National Infrastructure Planning  
Temple Quay House  
2 The Square  
Bristol, BS1 6PN

Our Ref: EN010127

### **Application by Mallard Pass Solar Farm Limited for an Order Granting Development Consent for the Mallard Pass Solar Project**

#### **Advice following issue of decision to accept the application for examination**

C:\USERS\GFLETCHER\PTV\PT - CAD\LDA_49902002_MALLARD_PASS SOLAR FARM\CAD11.0.CURRENT\11.0.1.SHEETS\PROWS\4990-2001-T-079-089-P1 - TRAFFIC REGULATION MEASURES PLANS - TEMPORARY MEASURES.DWG

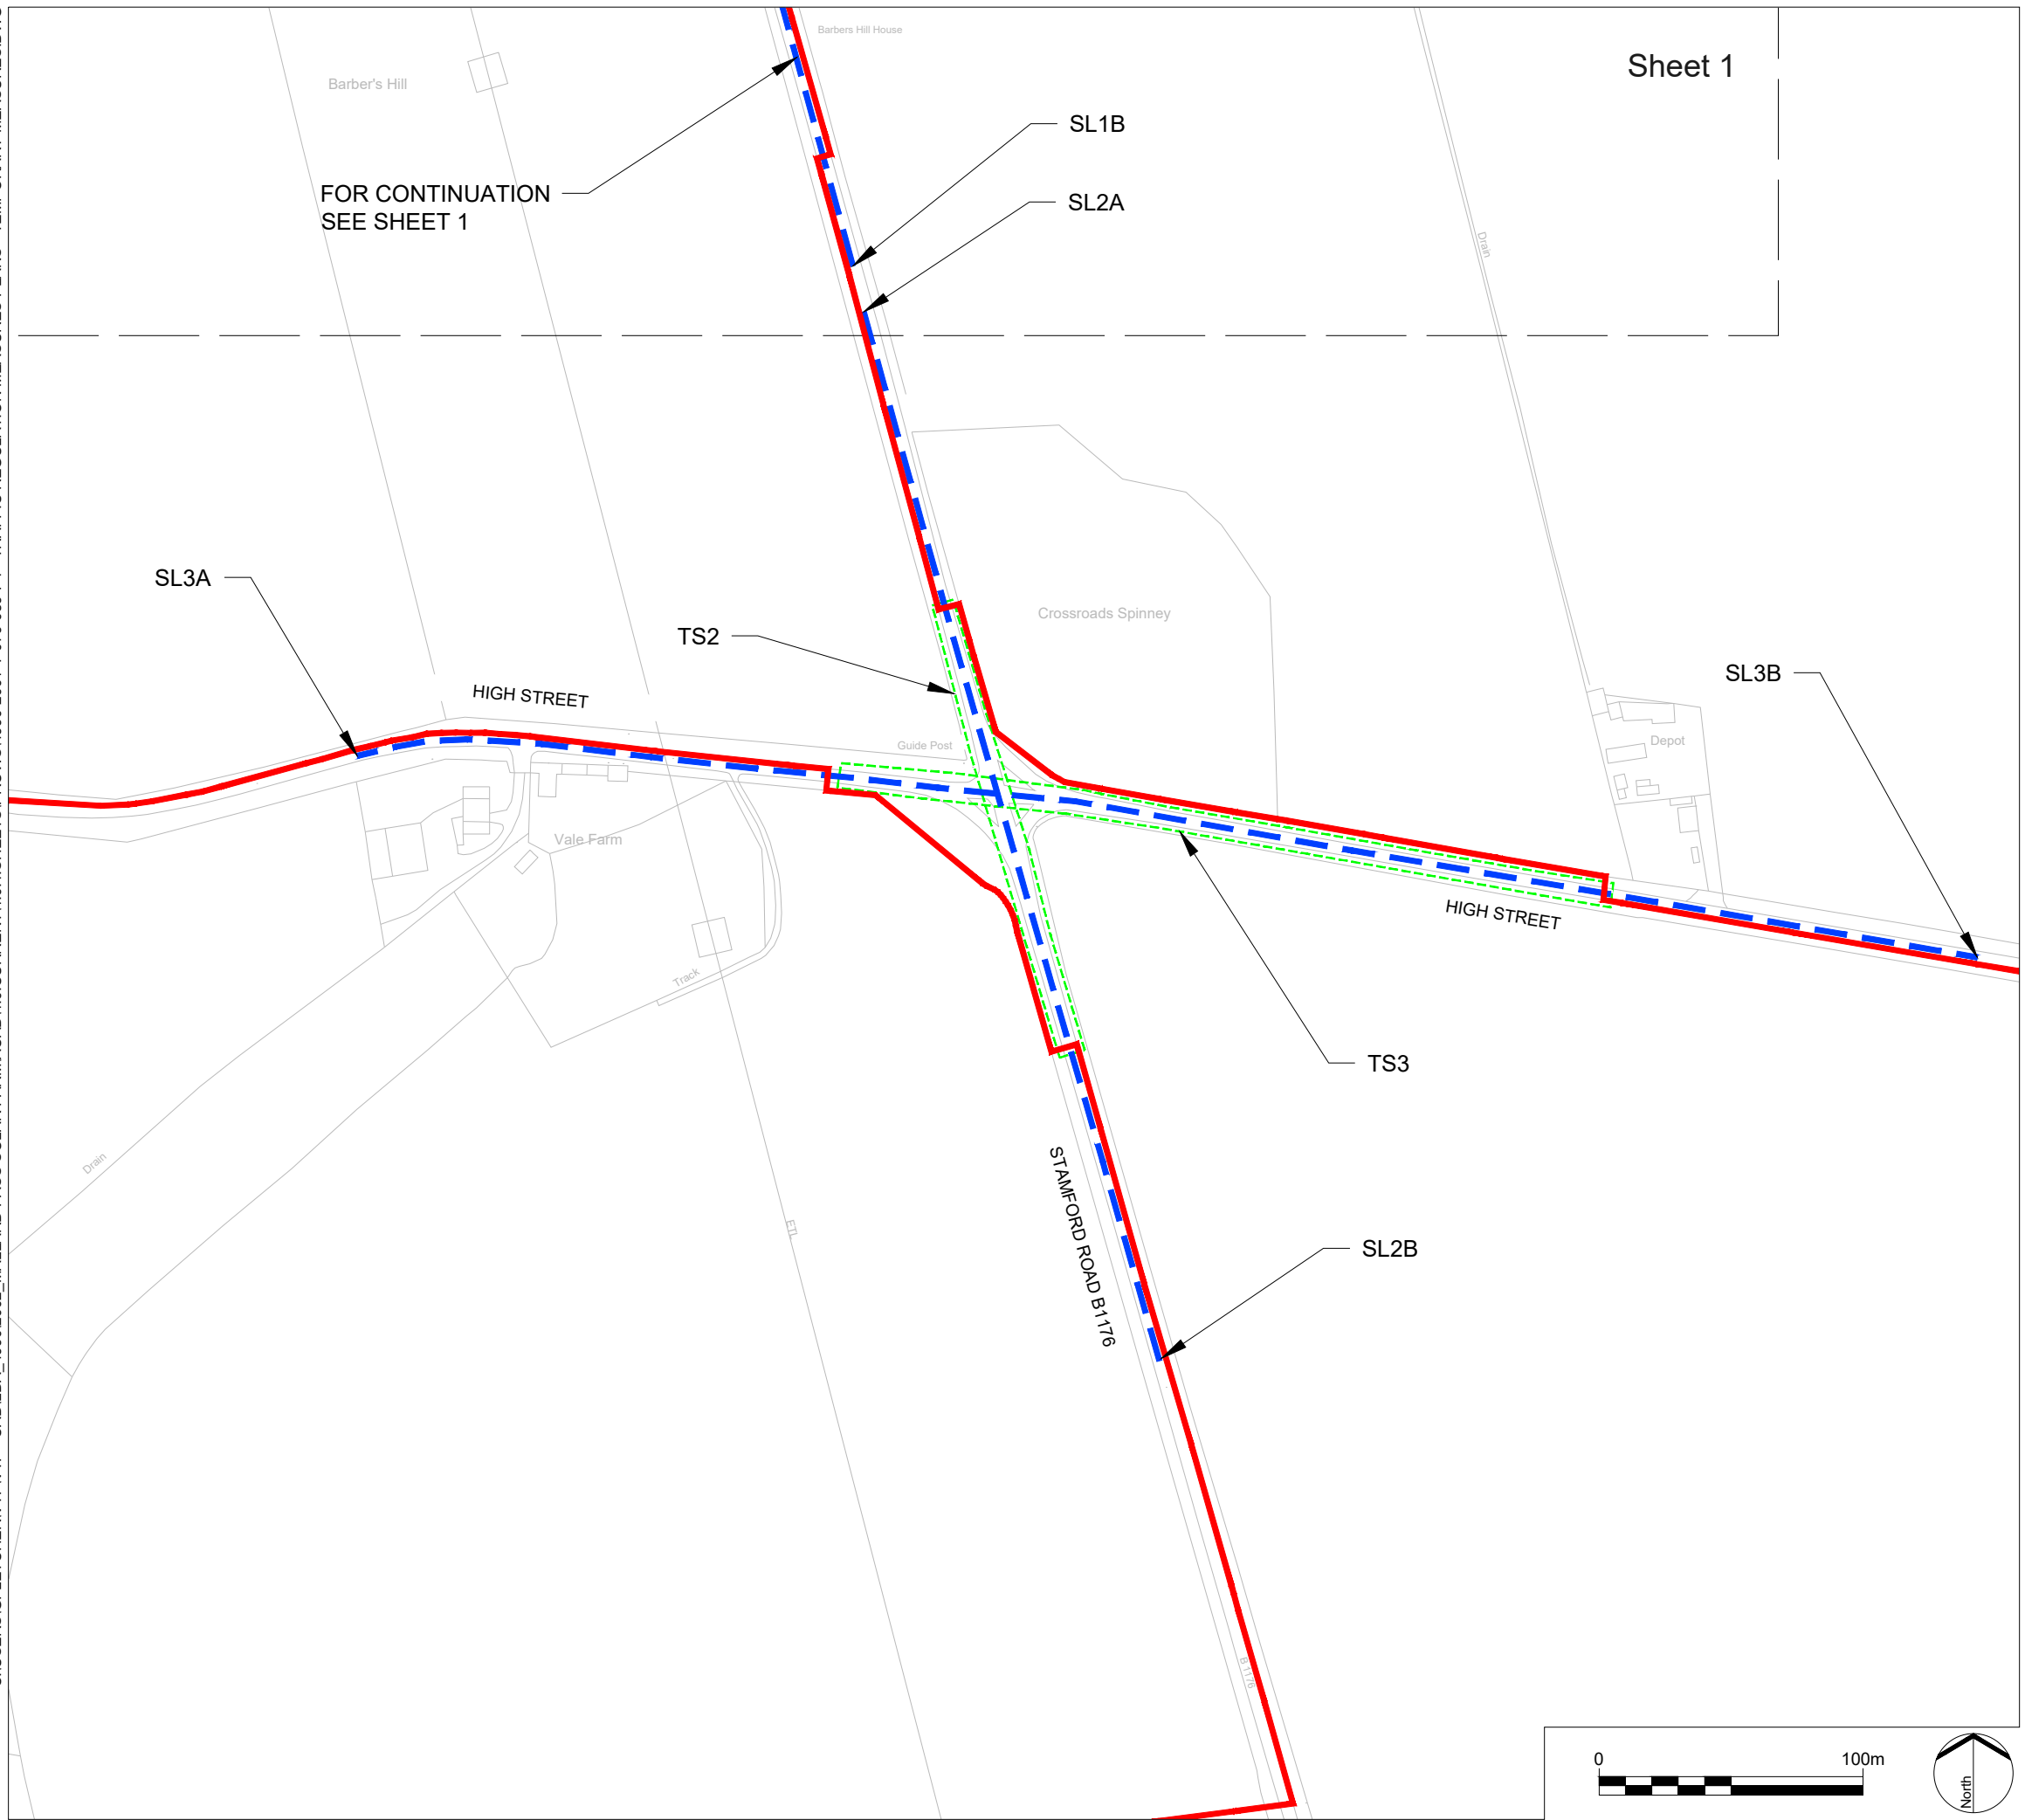
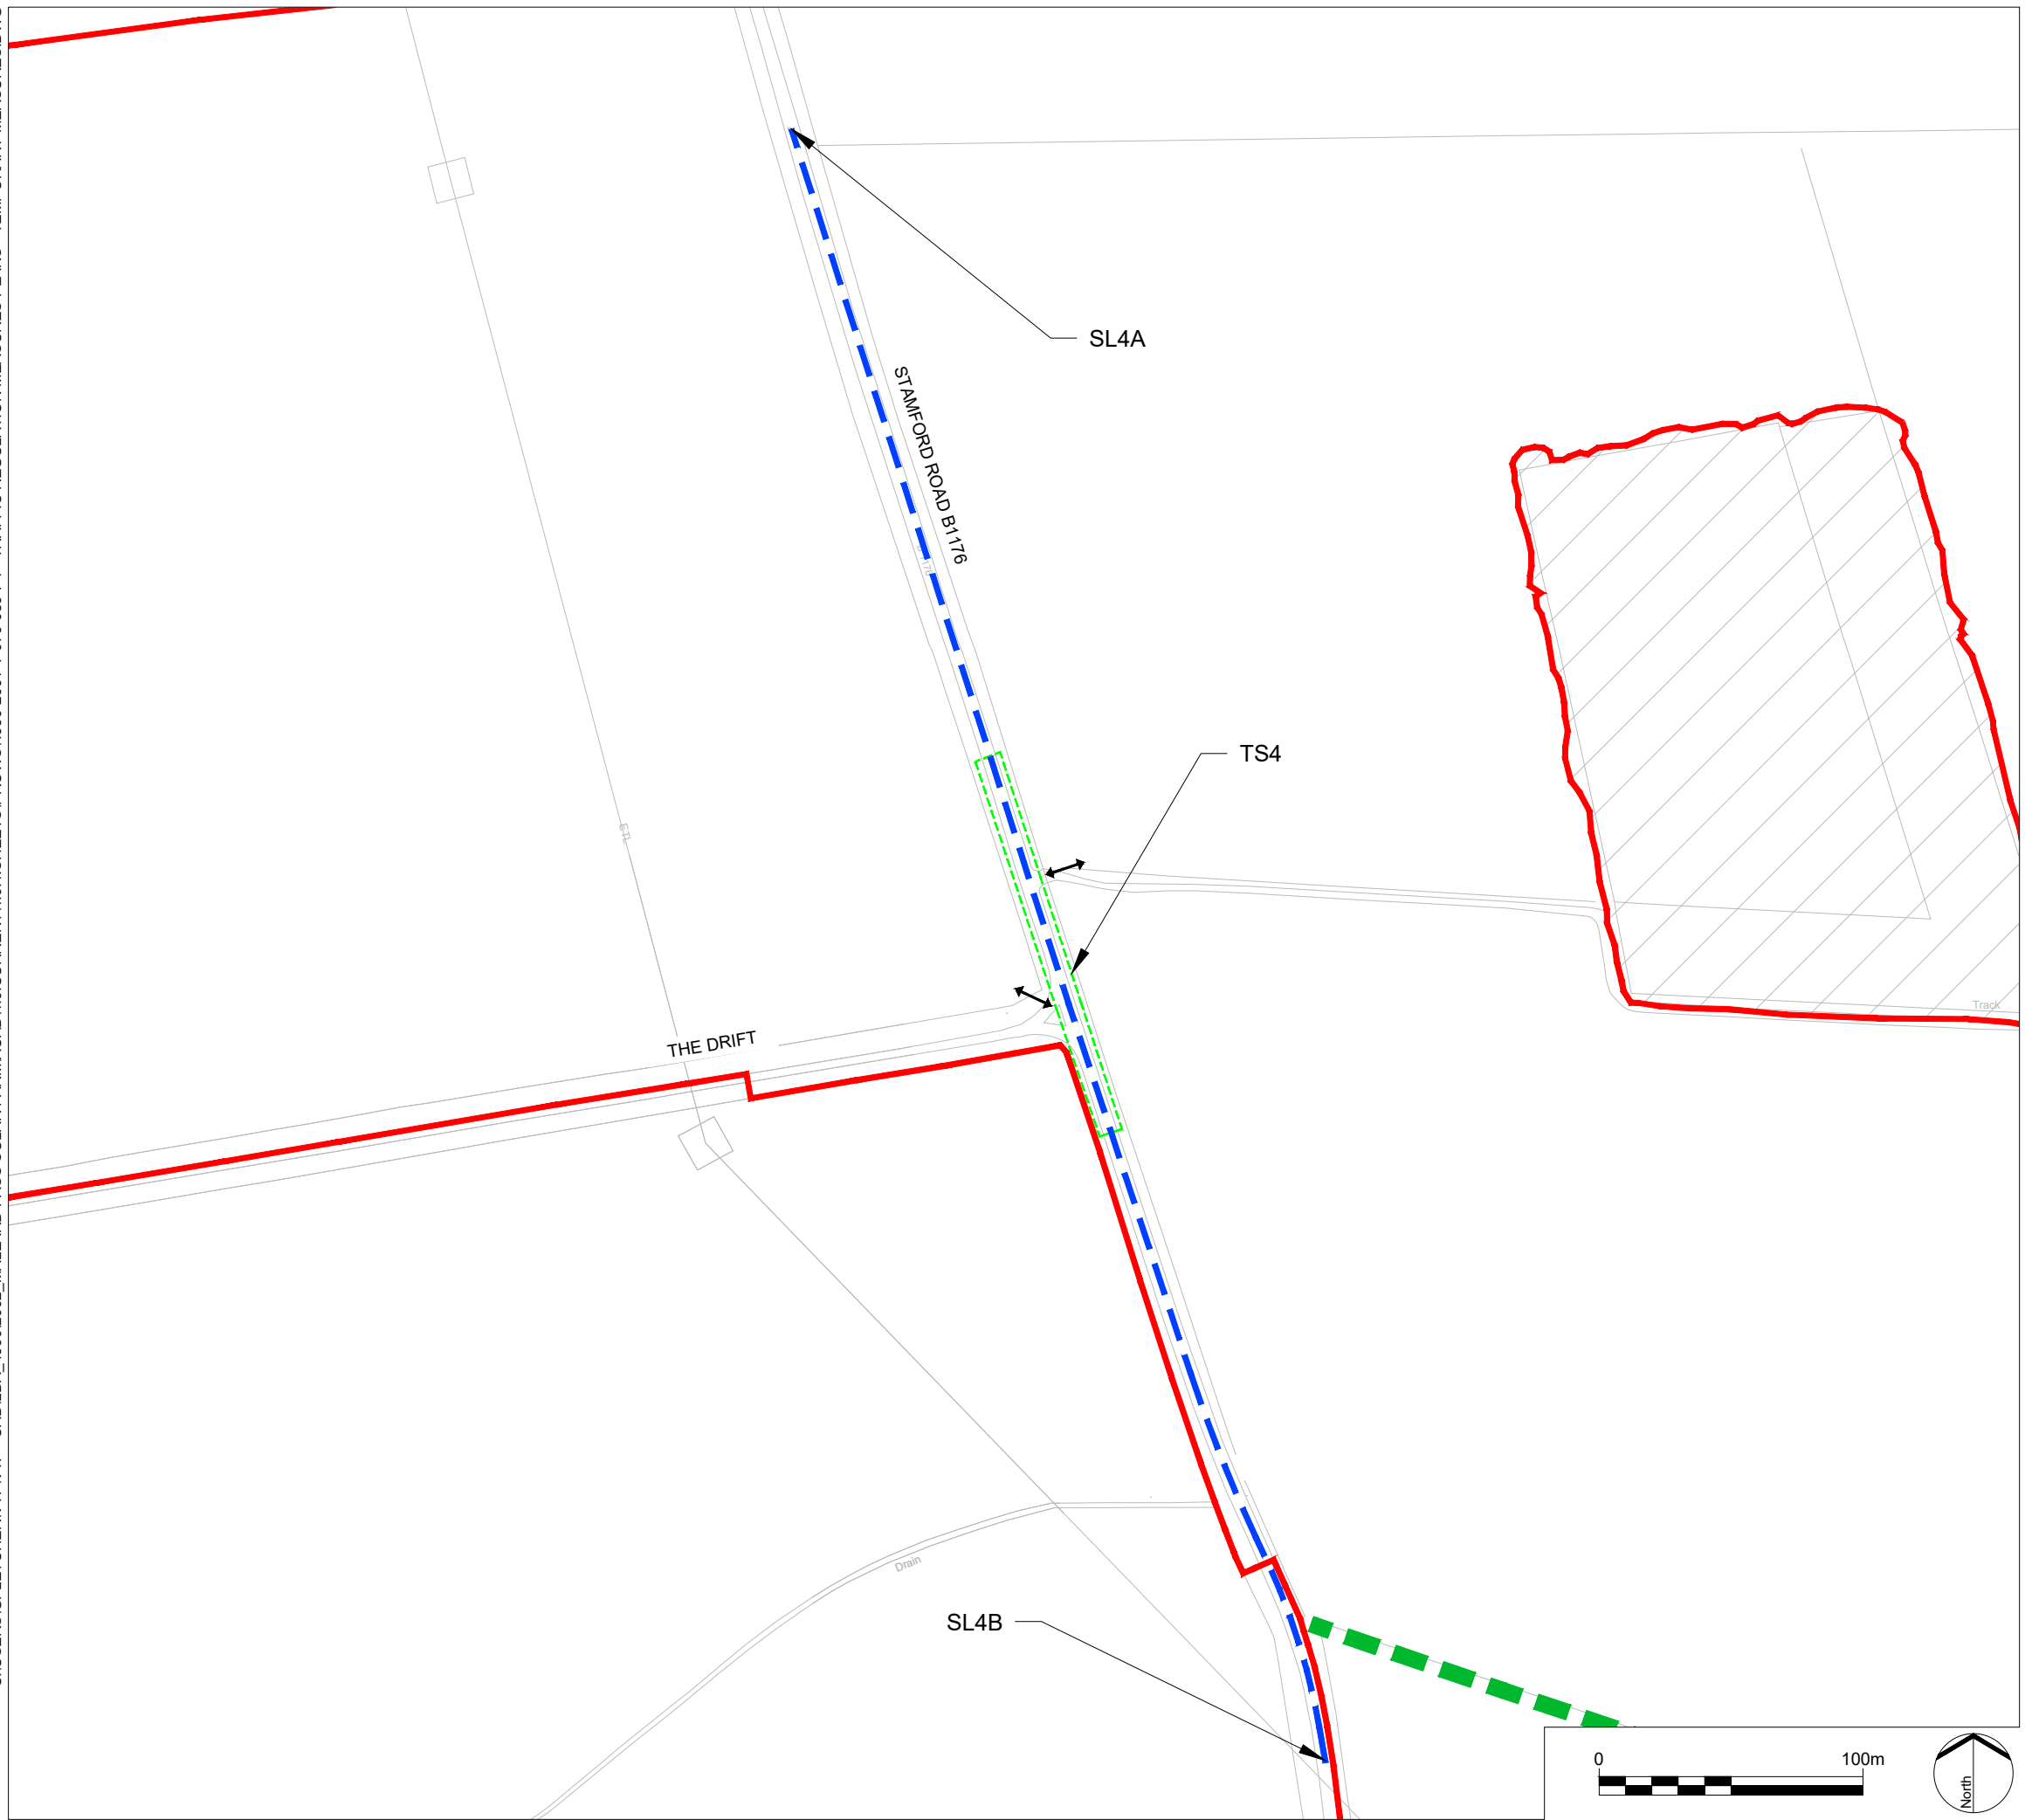
For clarity and to help understanding, existing public footpaths (public rights of way) should be marked and the plans more clearly notated to reflect the proposals, including differentiating works to footpaths and roads.
